Consultation Response from Biodiversity Officer
KC Ecology
2019/91327 Thongsbridge Mills, Miry Lane, Thongsbridge, Holmfirth, HD9 7RW
Reserved matters application pursuant to outline permission 2017/90207 for erection of B1 light industry
Date Responded:
01/08/2019
Responding Officer:
Tom Stephenson
Responding Ref:

Plan View

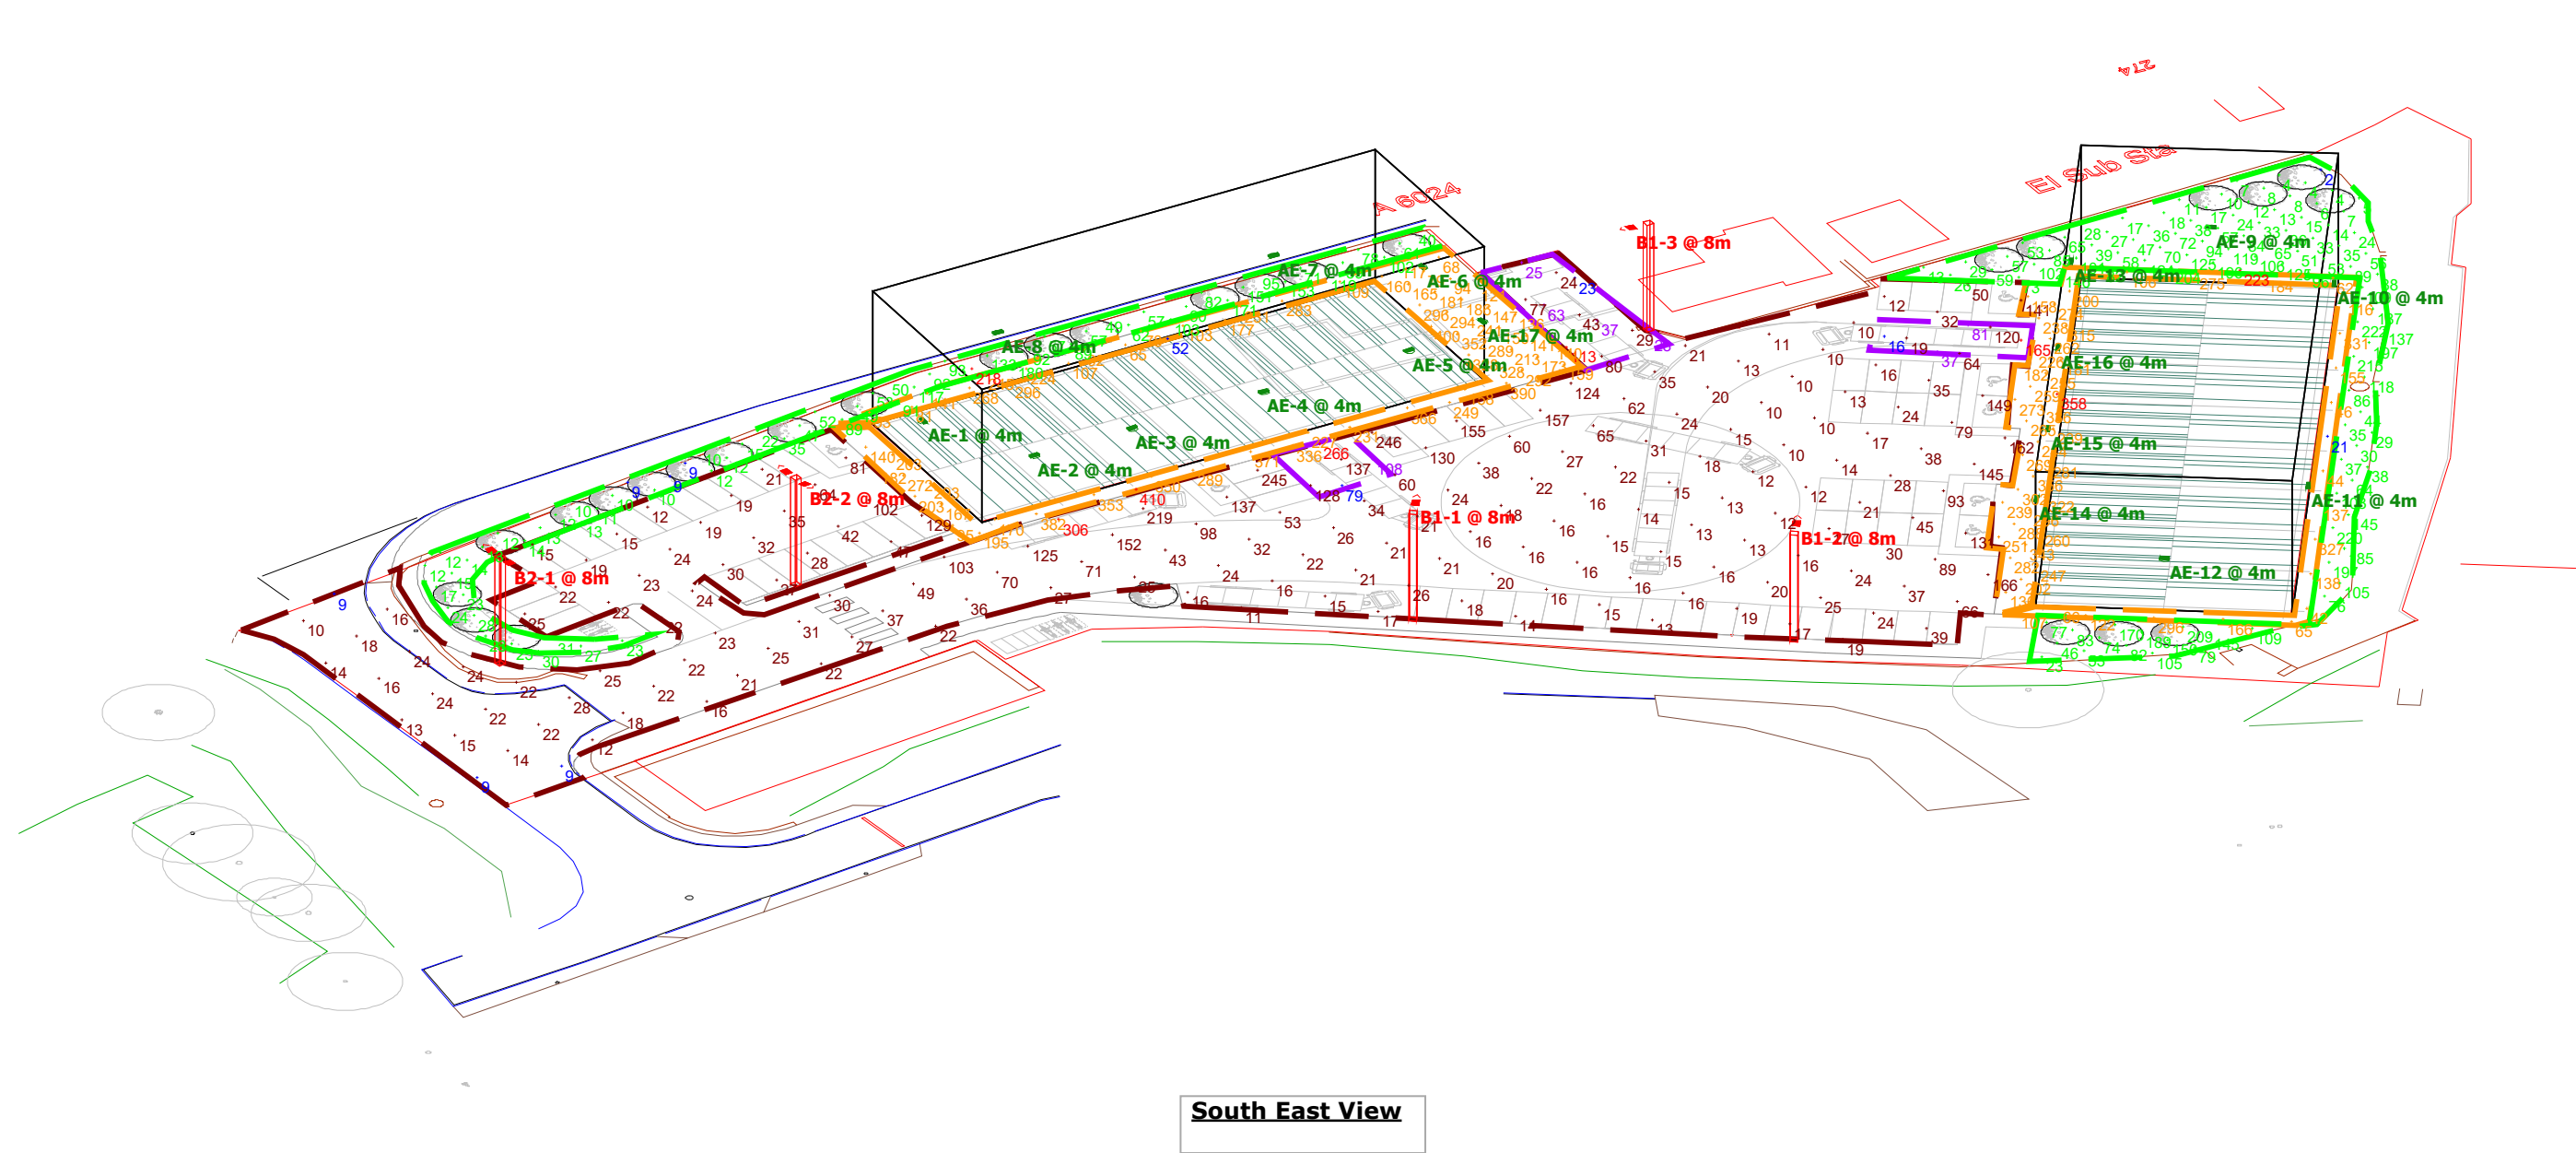
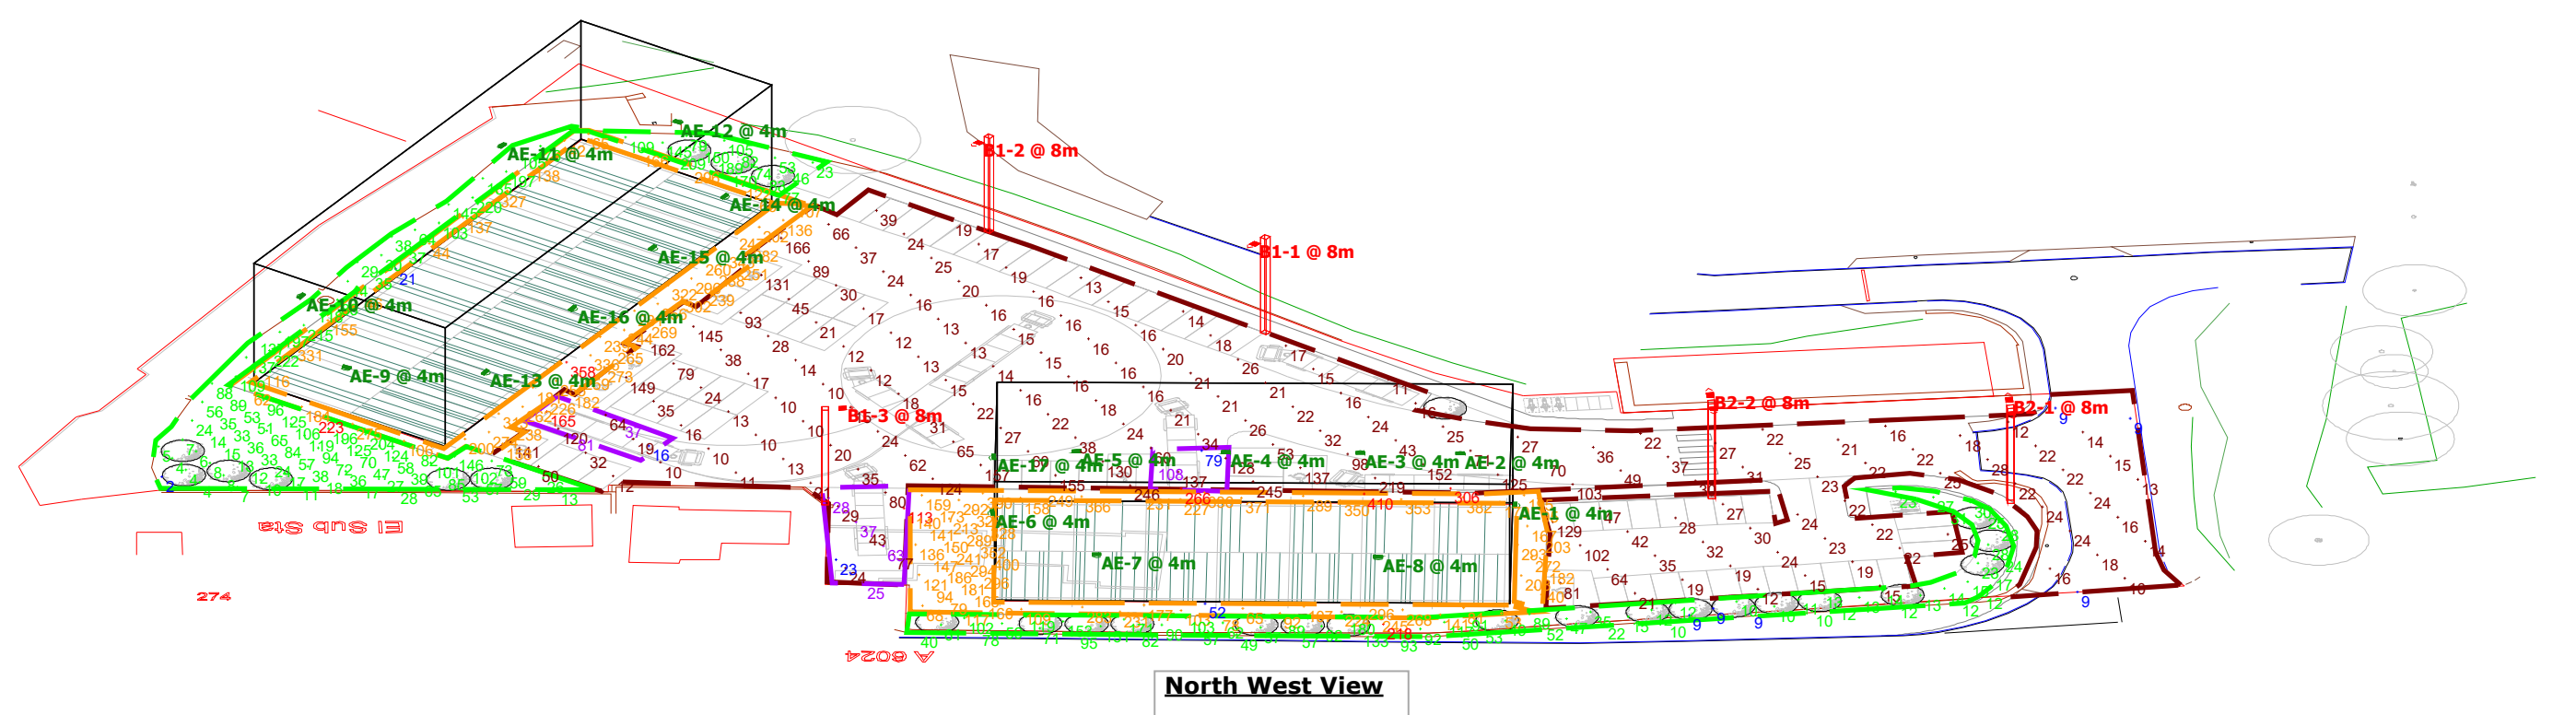
The lighting plan now displays the information needed to assess the requirements of the condition, but this shows that lighting level are too high to meet the objectives for a sensitive lighting strategy as set out in the EDS. To clarify, several species of foraging bats show avoidance behaviour where light levels exceed 3.5 lux. In order to facilitate the use of the areas of native planting by foraging bats the lighting design will need to be amended to include dark corridors that connect native planting areas with the nearby watercourse.
